CITY OF ALBUQUERQUE

February 07, 2012

**Re: Family Dollar, Tract A-5, Under Sage And Unser Marketplace
Grading and Drainage Plan
Engineer's Stamp Date 1/19/2012 (M10/D019A)**

OFFSITE DESILTATION POND

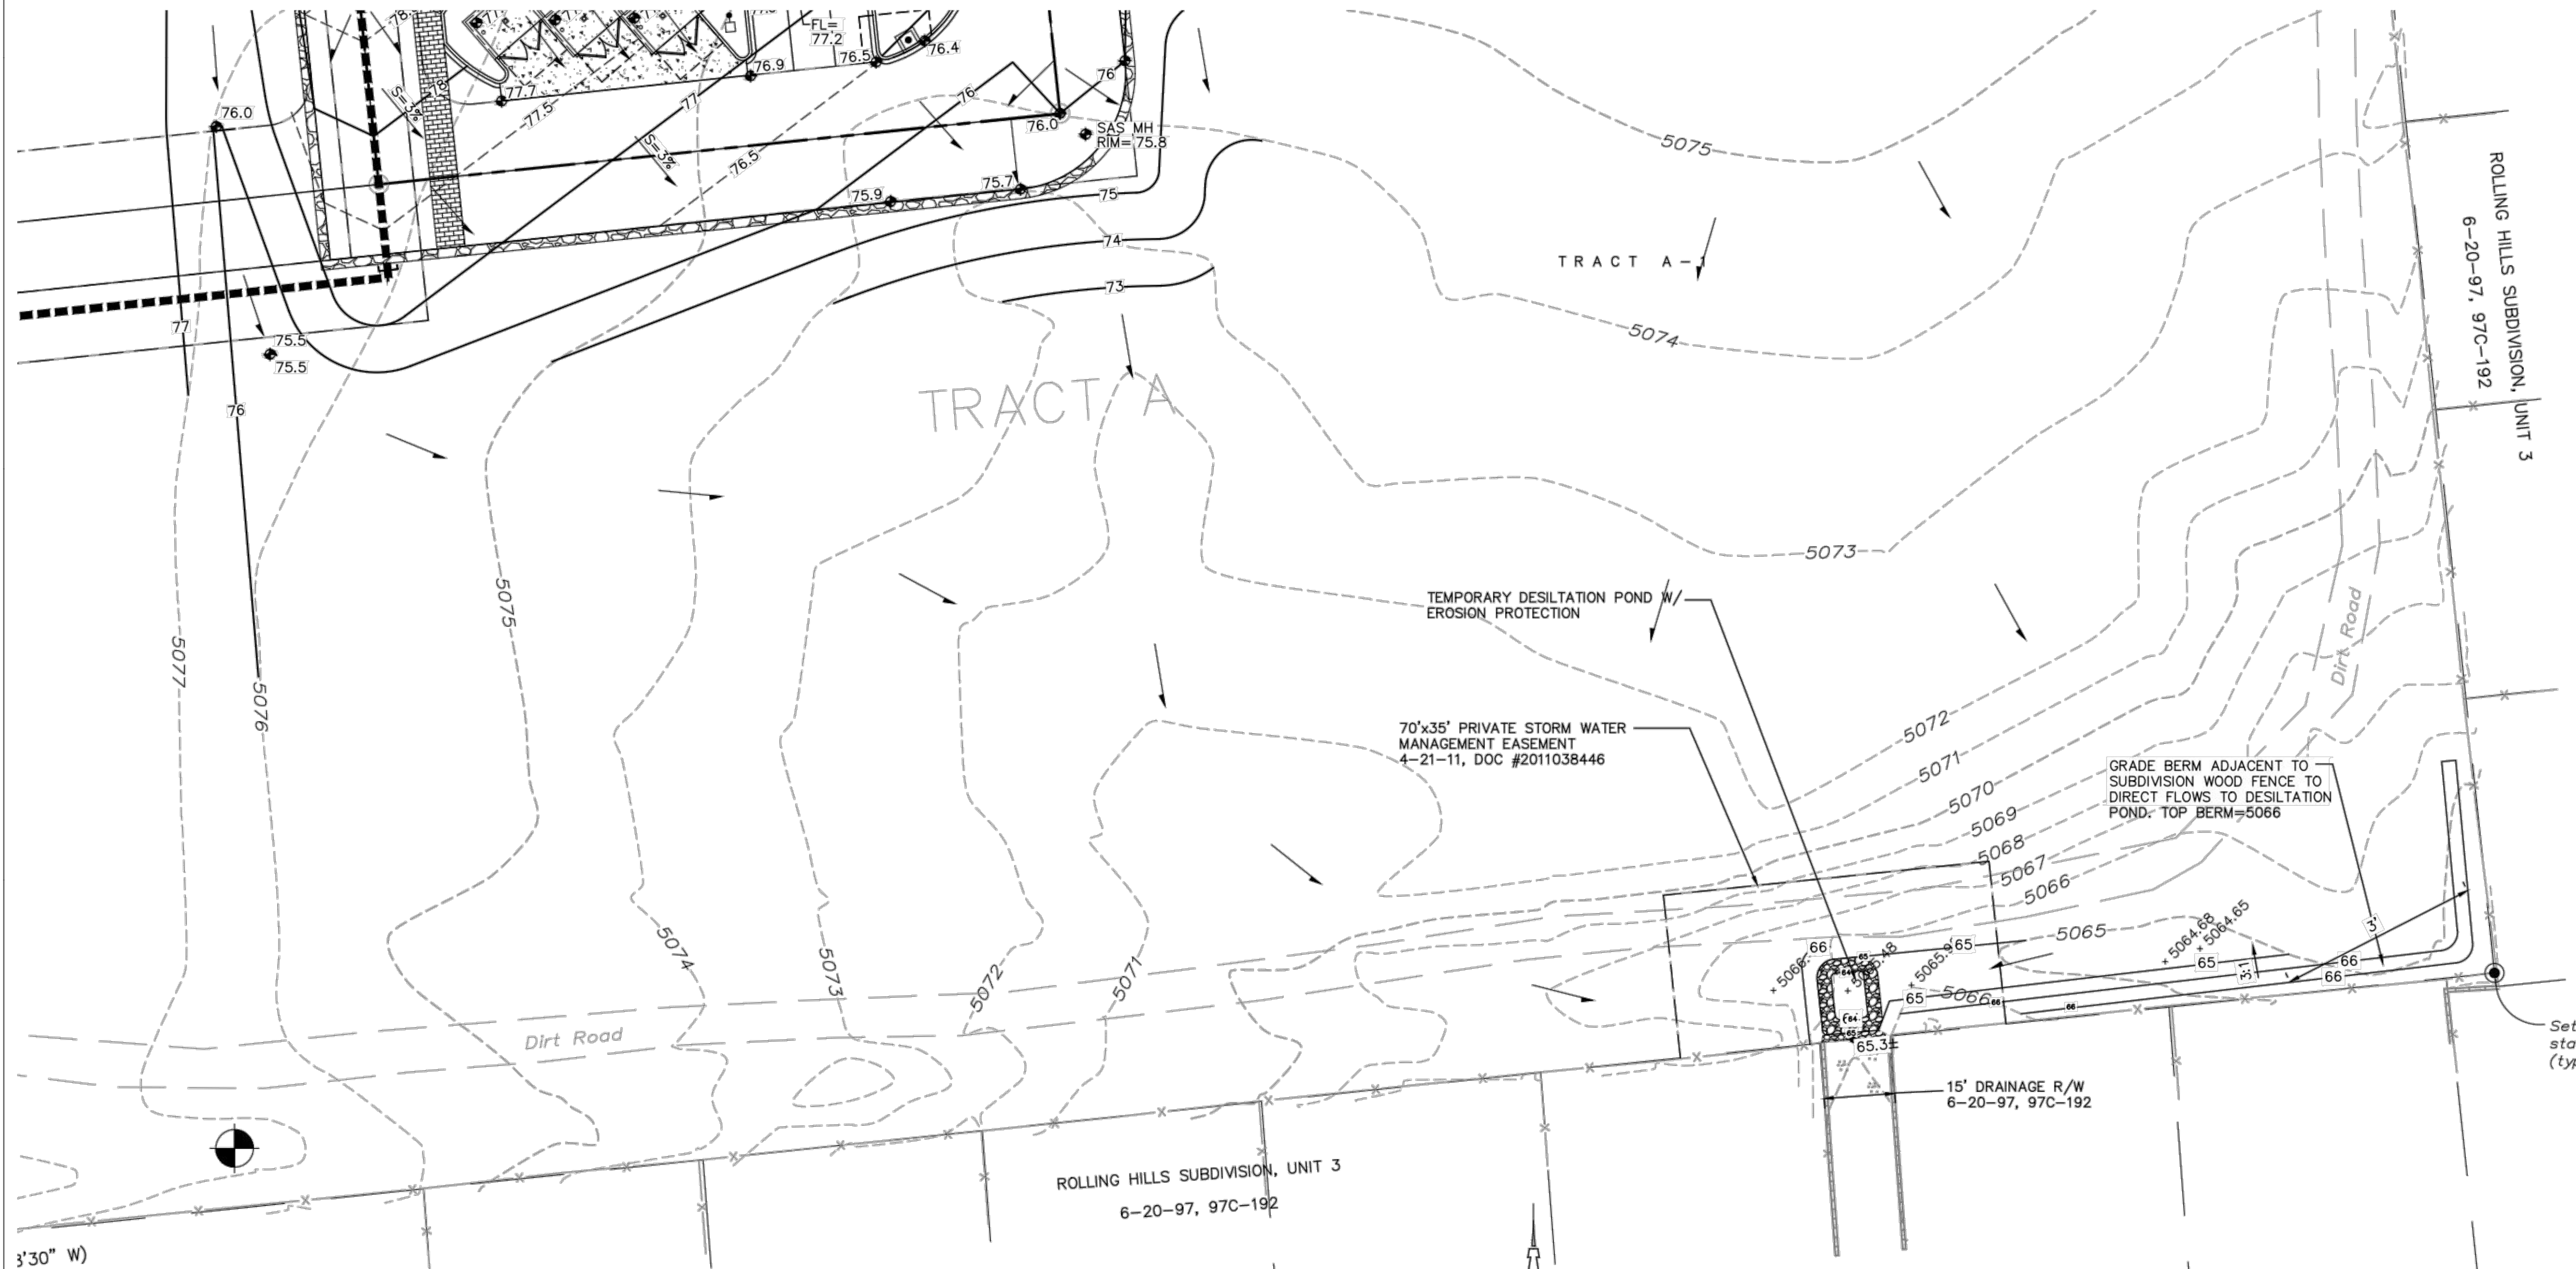
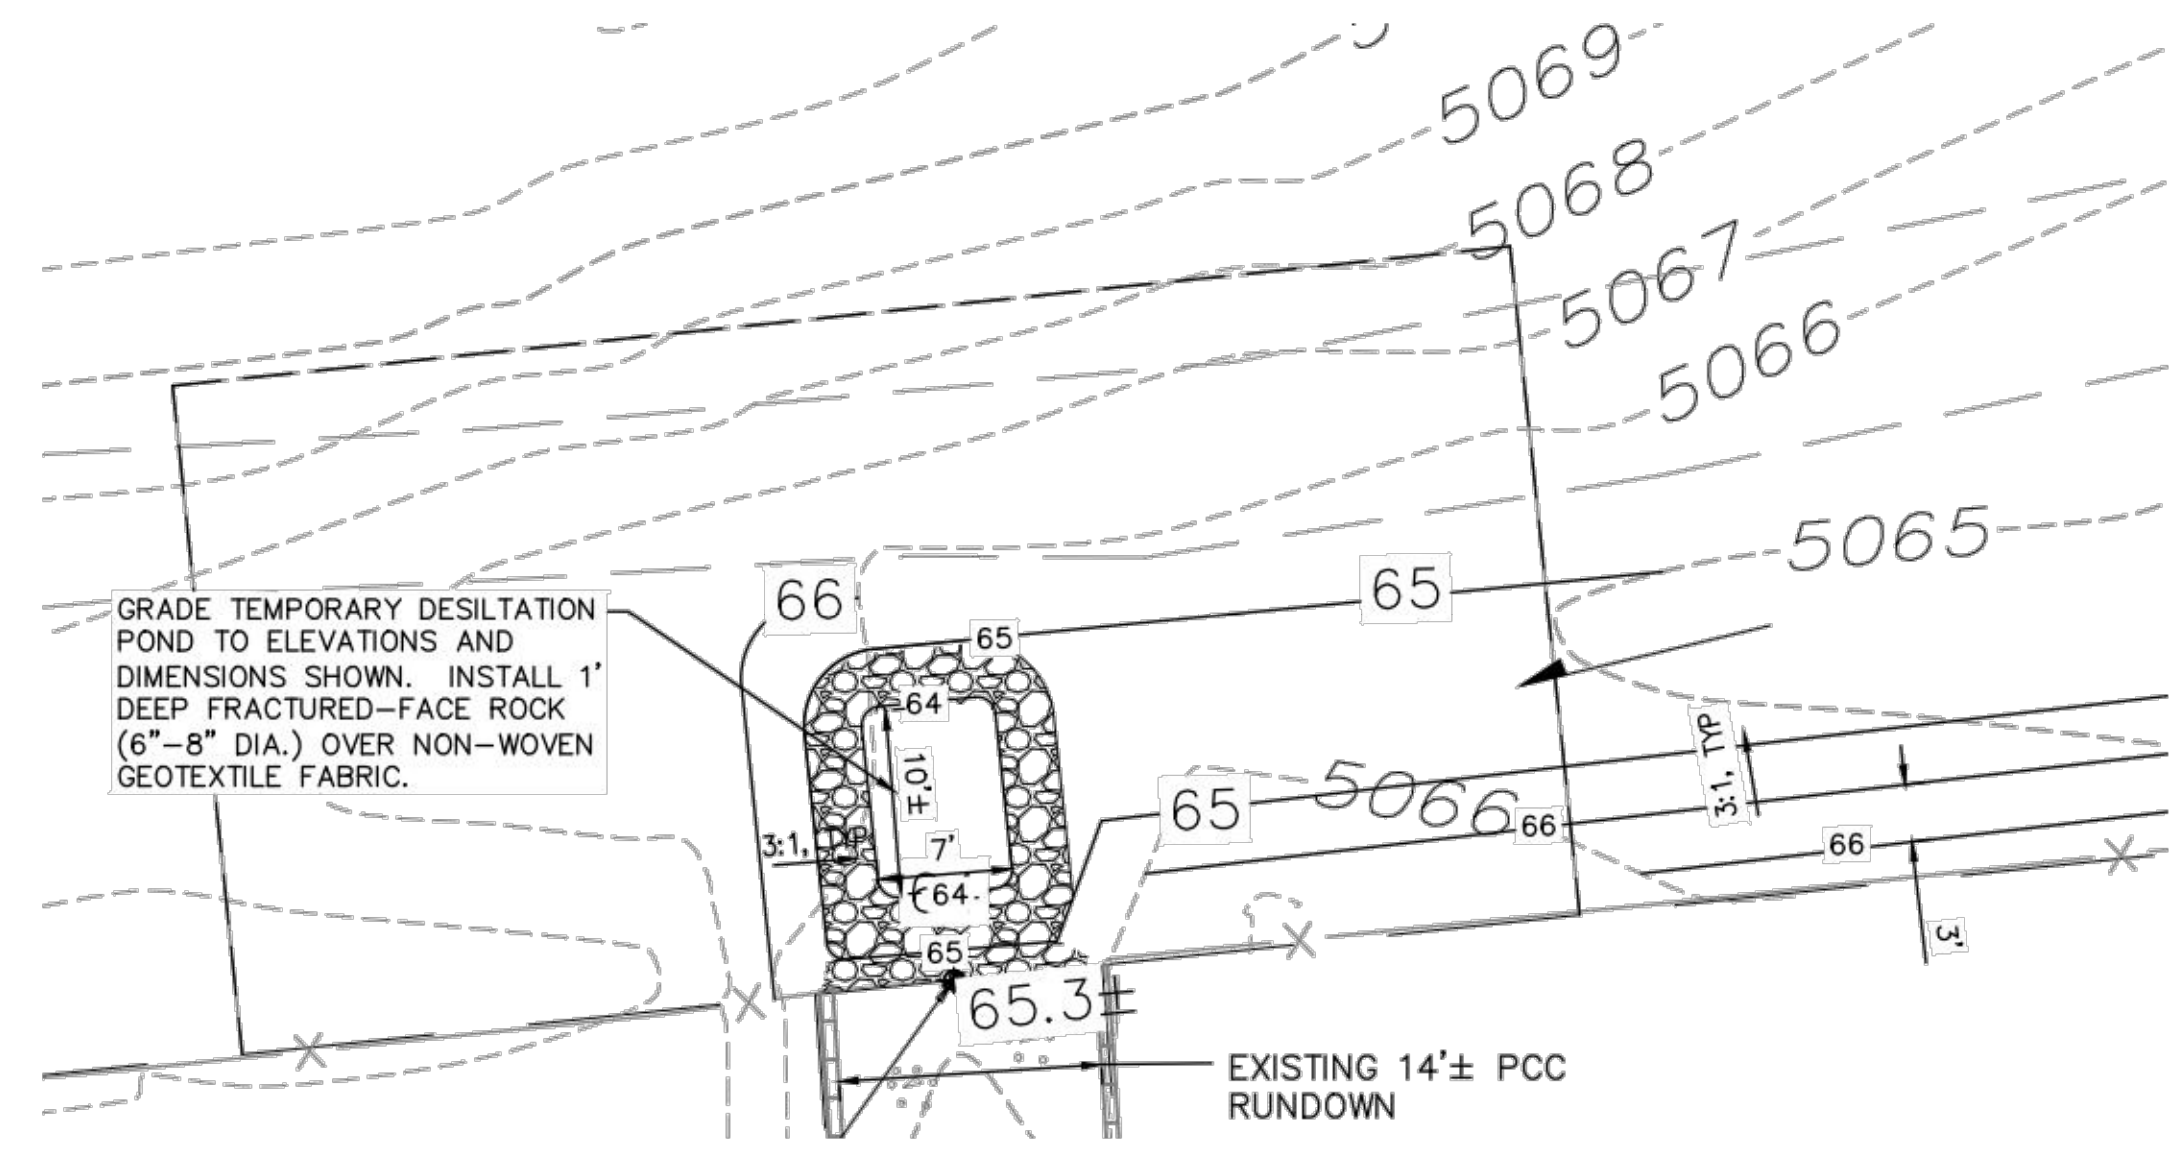
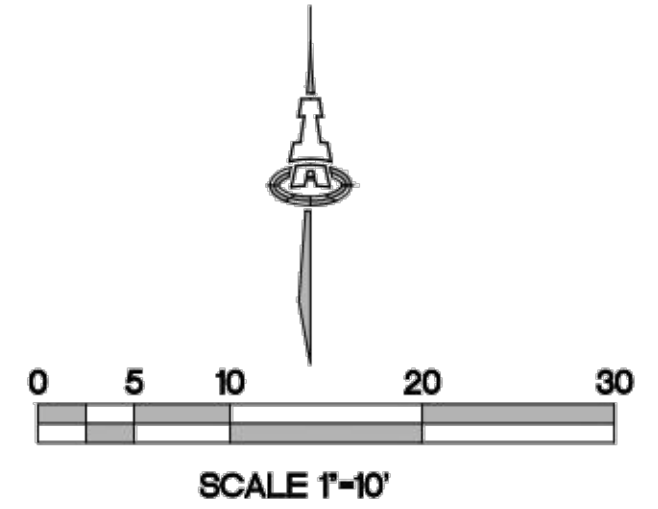
- Since the entire site will be graded under the developed conditions no Treatments A will be used for runoff calculations. Please modify your runoff calculations.
- Back portion of the Tract A-5 and Tract A-1 drain south. Therefore, storm drain extension to the south should not be necessary.
- Is there an existing swale to assure that the runoff will drain to the existing 15' drainage easement? Is there an existing desilting pond prior to runoff entering the 15' drainage easement? Please show the existing or the proposed drainage swale and delisting pond.
